**From:** Mark Sibley <[REDACTED]>  
**Sent:** 16 June 2021 16:21  
**To:** Kathryn Welch  
**Subject:** Re: 43 Mallon Dene R/88/21/CLP

**From:** Kathryn Welch <Kathryn.Welch@arun.gov.uk>  
**Sent:** Wednesday, June 16, 2021 4:17:45 PM  
**To:** [REDACTED]  
**Subject:** 43 Mallon Dene R/88/21/CLP

PROPOSED REAR ELEVATION

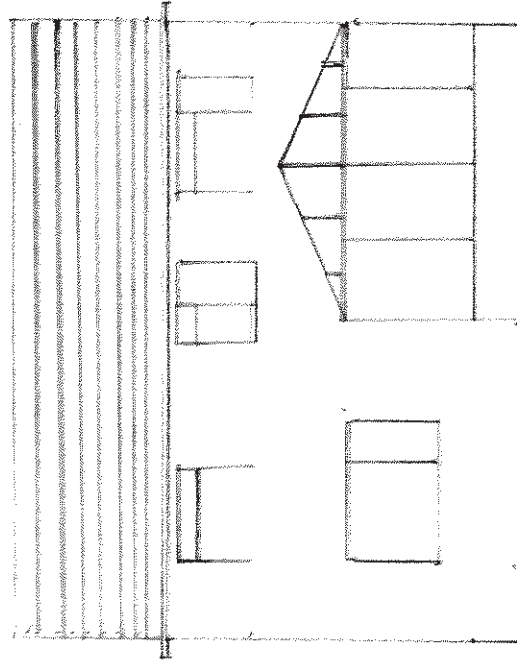
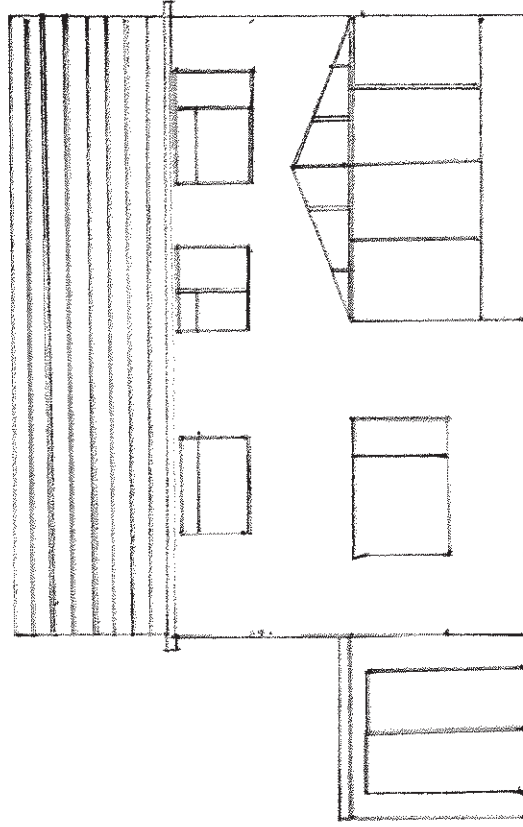
I would be grateful if you could confirm in writing that the facing bricks proposed in the construction of the proposed extension will match existing brick work found at the property?

Yes the face bricks will match the existing bricks  
As the existing bricks are painted white  
Kind Regards  
Mark Sibley
